**Bulli Seam Operations Project (MP08\_0150)**  
**Appin Mine Extraction Plan LW709 to 711 & LW905 – Request for Additional Information**

## Attachment 1 – Surface and Groundwater Issues

Figure 1 Surface water monitoring reconnaissance for the proposed longwalls.

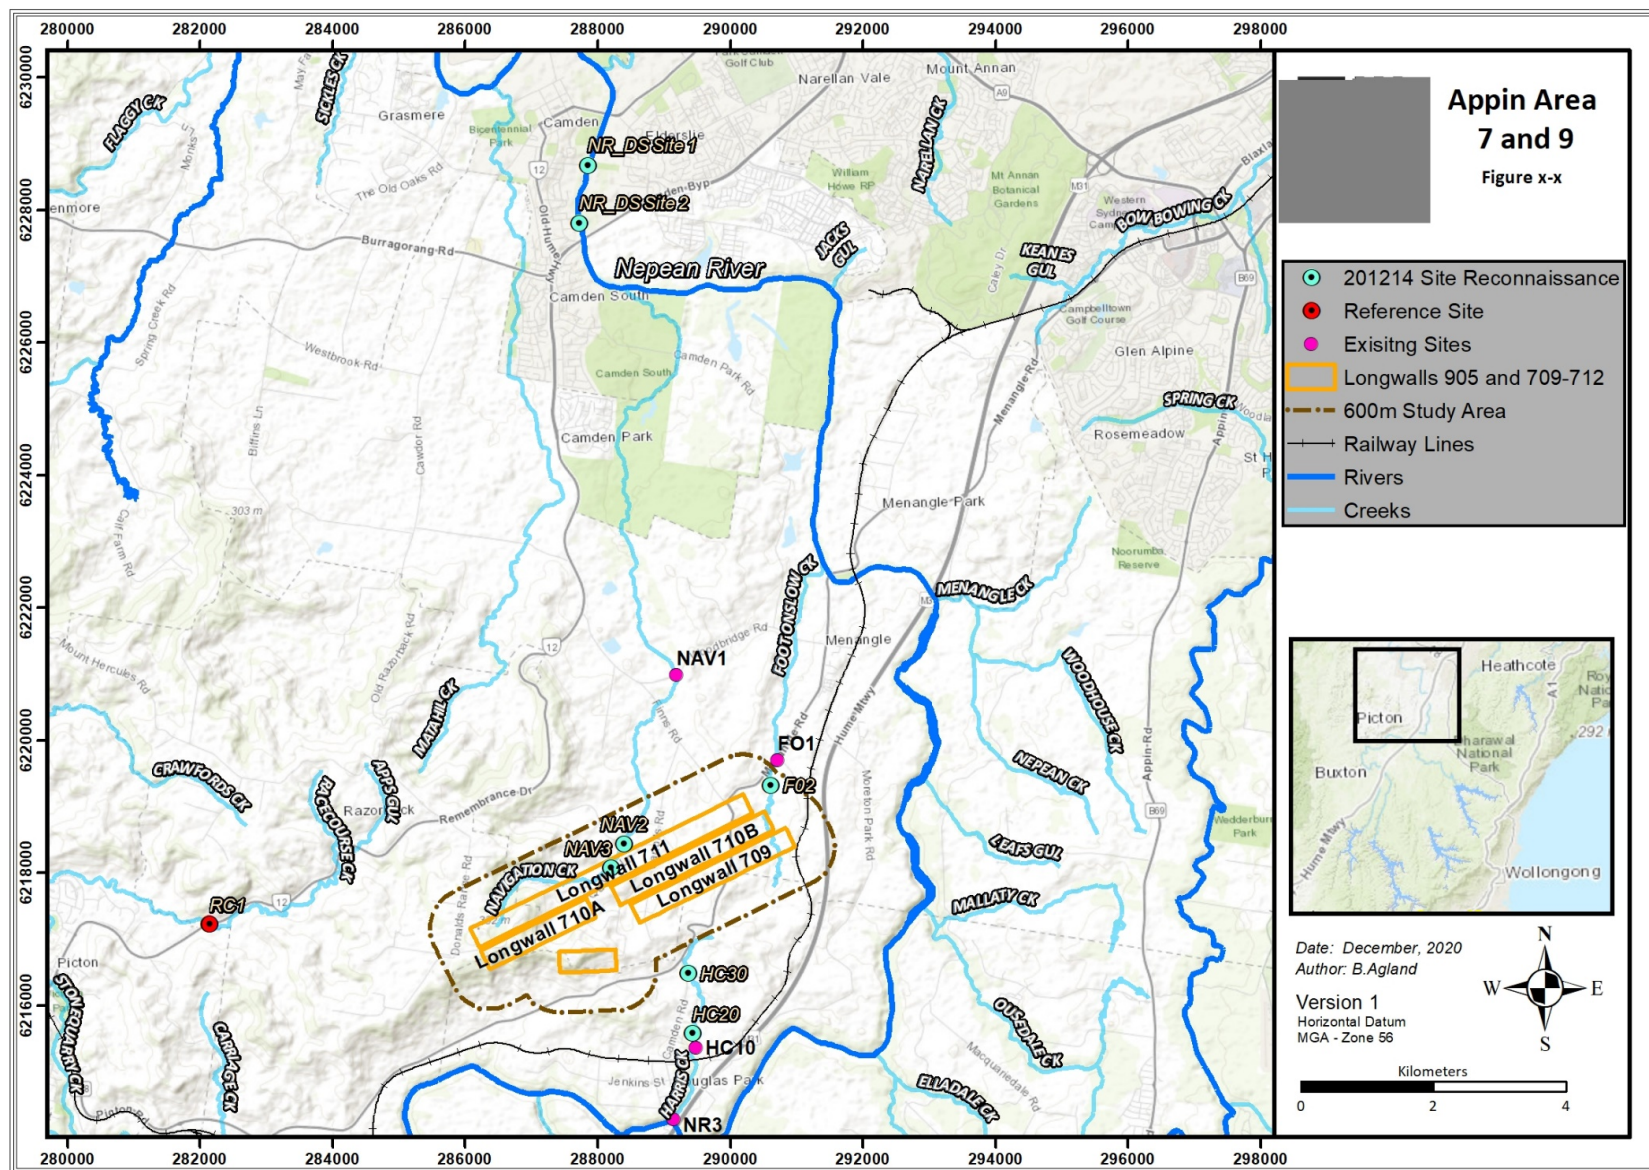
The surface water monitoring sites shown in Figure 8 of SLR (2021) and Figure 4 of SLR (2022) do not include any flow monitoring in watercourses or water level monitoring in pools over the proposed longwalls or at the existing NAV1, FO1 and HC10 water quality monitoring sites.

The Department requests IMC update the existing monitoring program, or provide justification otherwise, for additional monitoring of flows and standing water levels in watercourses above and adjacent to the proposed longwalls.
